Havering
LONDON BOROUGH

30th June 2021

London Borough of Havering (20025659) – LB Havering response to the Applicant’s comments on LB Havering’s Deadline 7 submissions. (REP8-013)

Project Title	M25 junction 28 improvement scheme
Drawing Title	DESIGNATED FUNDS - NMU ROUTE BROOK STREET ROUNDABOUT
Drawing Number	HE551519
Project	J28
Originator	ATK
Volume	HGN
Type	DR
Role	CX
Number	00001
Original Size	A1
Scale	1:500
Project Ref. No.	5158157
Sheet	1 of 1
Rev.	C02

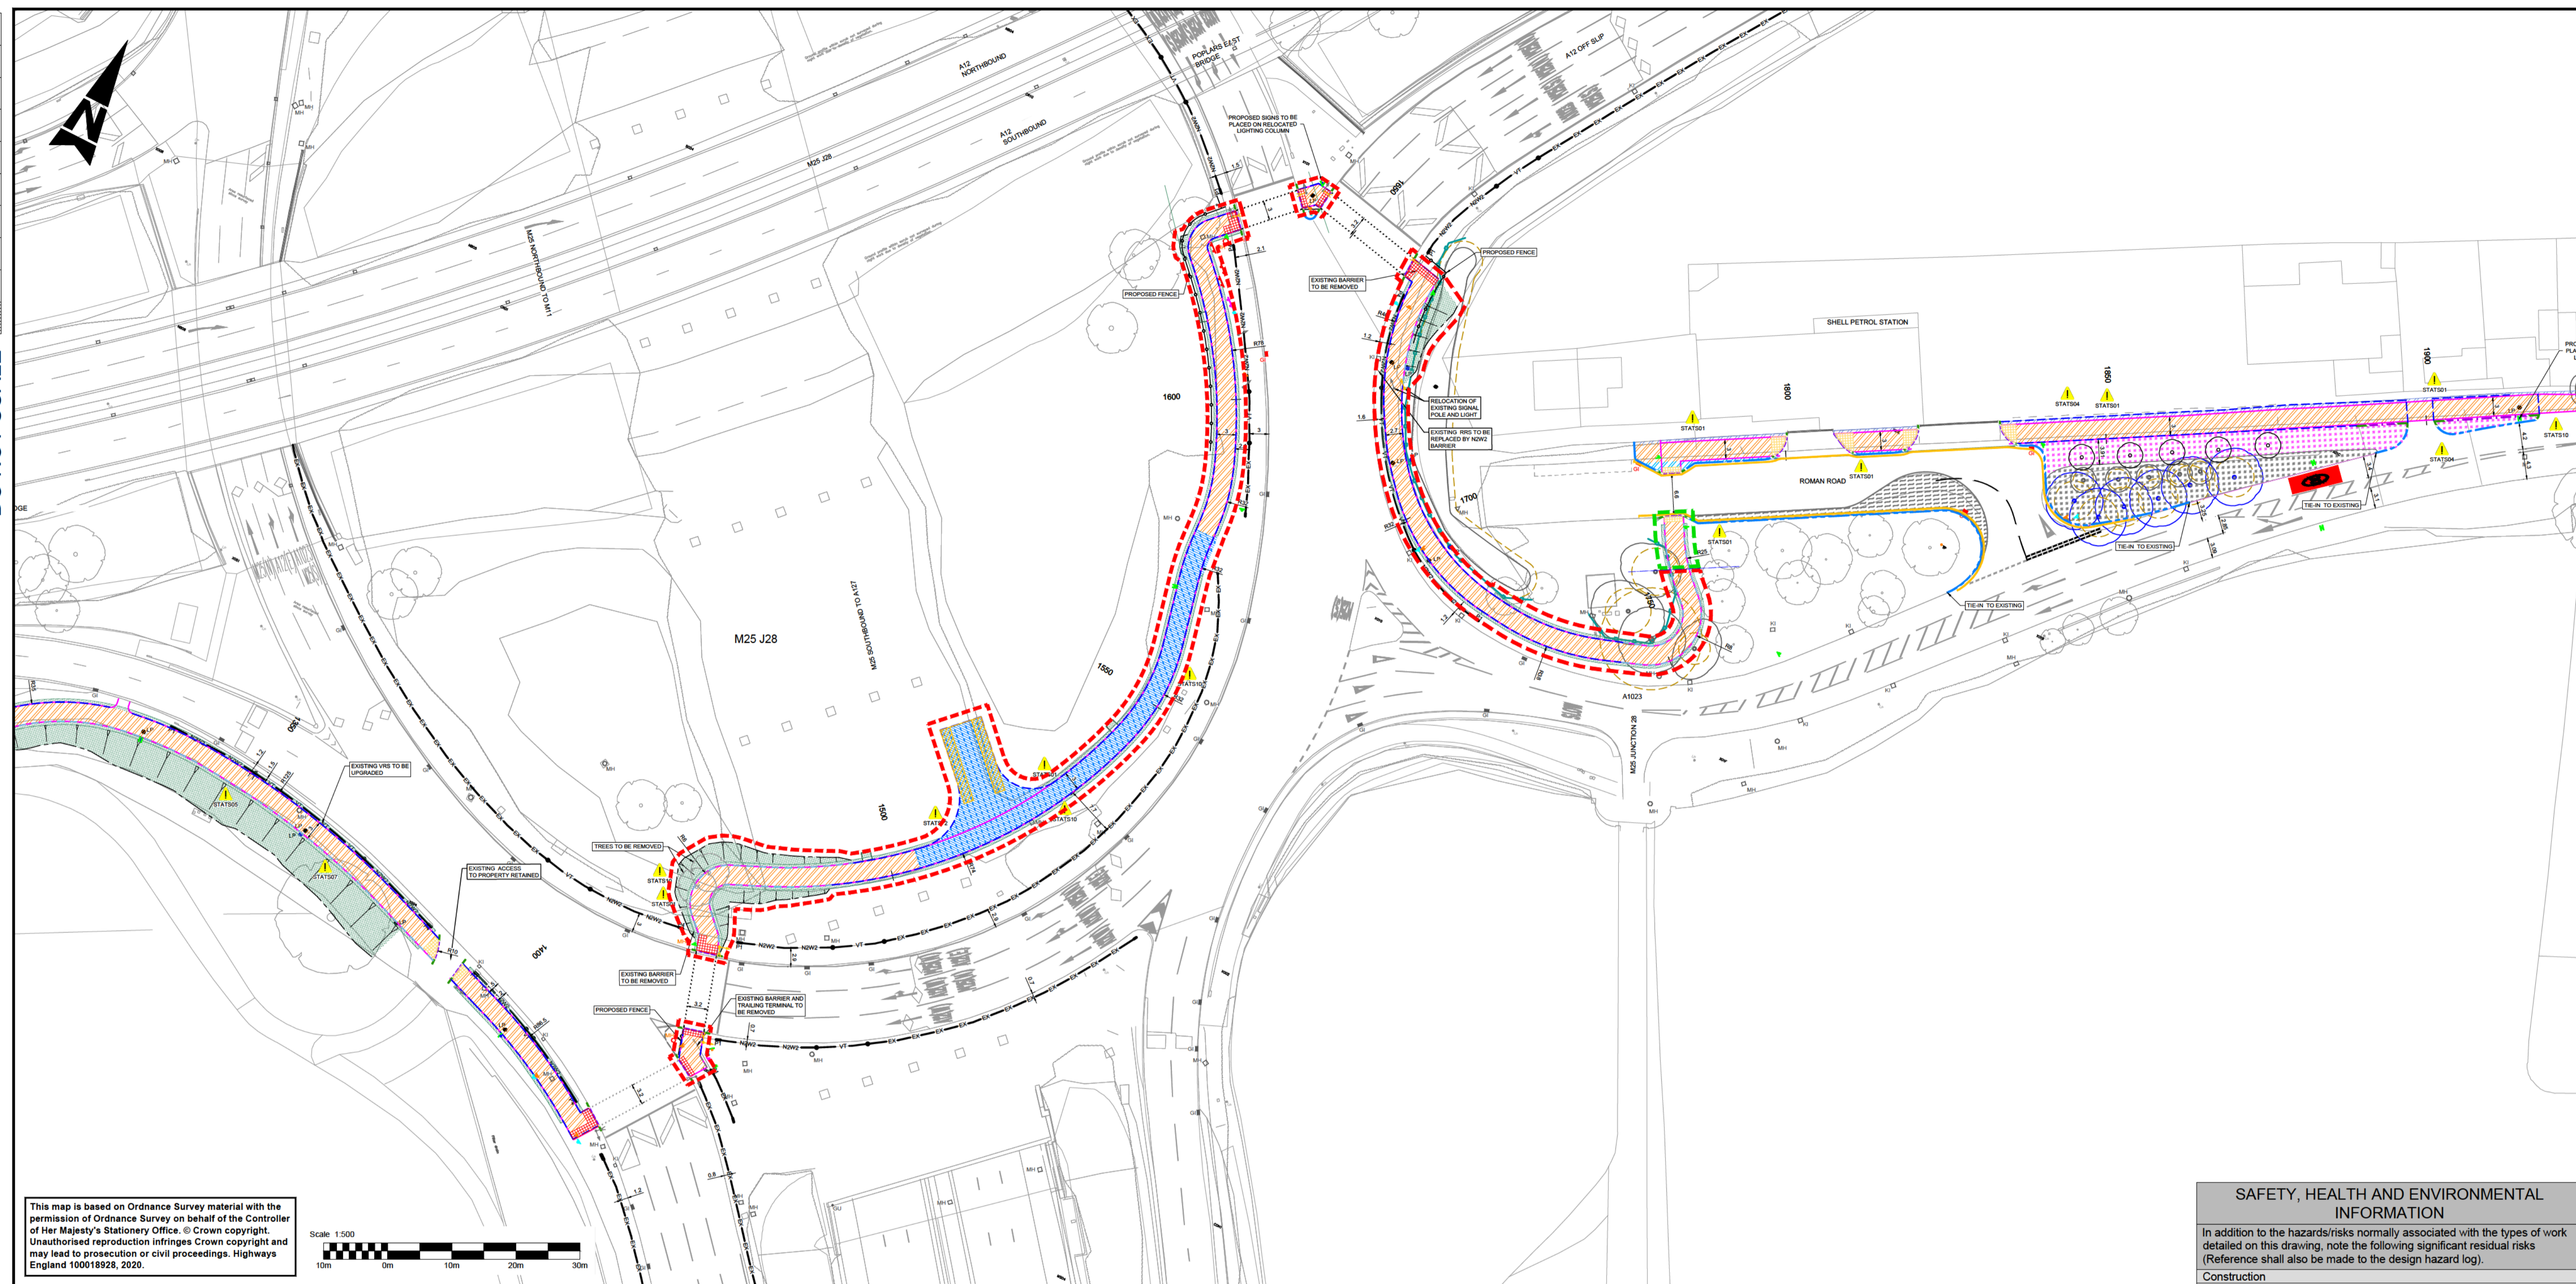
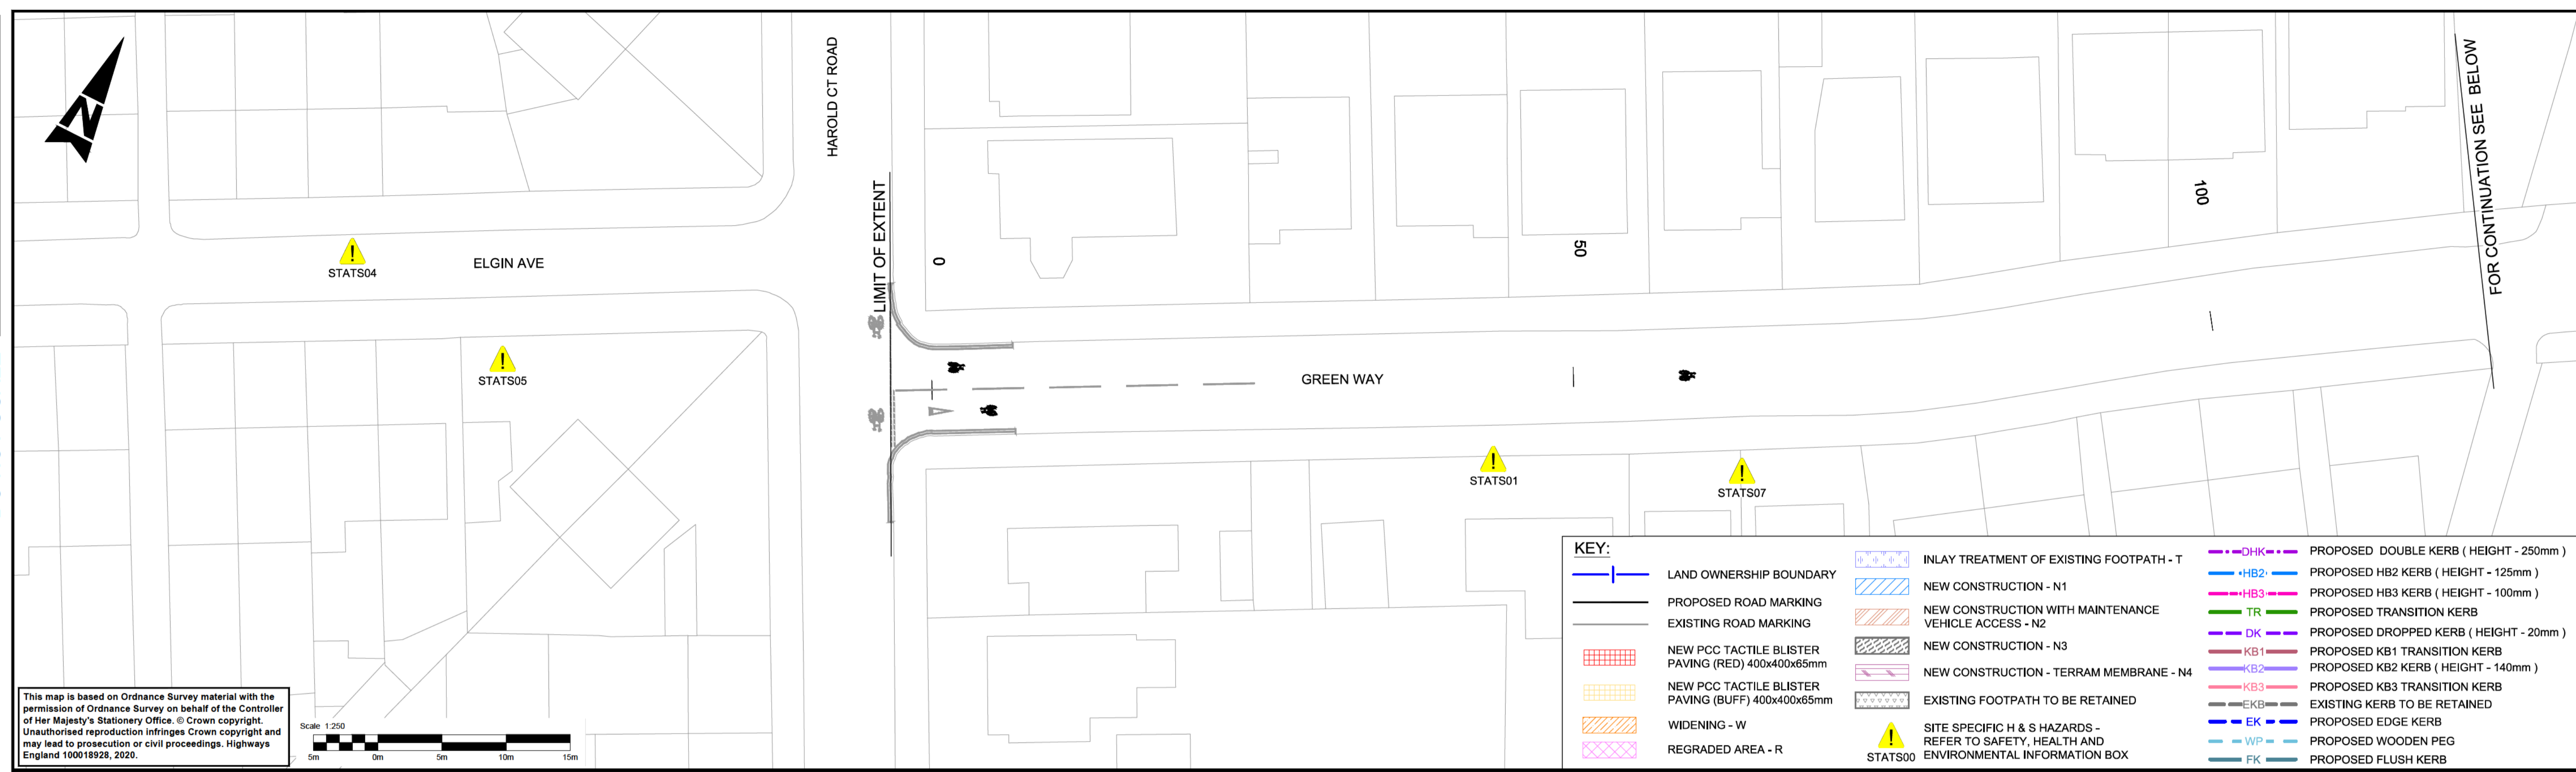
With regards to REP7-033-02 concerning the provision of the NMU route from Brentwood to Harold Hill, Havering notes the Applicant’s statement that it will deliver not only the central section of the route through the junction but in due course the entire NMU scheme.

Havering has recently entered into discussions with the Applicant concerning the drafting of the S106 agreement that would secure the provision of the NMU route. At present HE’s initial draft S106 only deals with the provision of the central section of the NMU route. This leaves Havering with concern as to how the entire NMU route will be secured. Following discussions with Transport for London and Essex County Council, LB Havering has sent a revised version of the S106 agreement to the Applicant for their consideration. This includes some additional wording to the obligation that all authorities feel is an essential requirement to provide the surety that the respective local authorities need that the NMU route will be delivered in its entirety by March 2025.

Given that the Examination will close on 7 July 2021 and the fact the Applicant has already stated to Havering that there is little time to secure a S106 for the entire NMU route, Havering requests that the ExA gives consideration to the provision of a Requirement in the draft DCO to secure the entire NMU route.
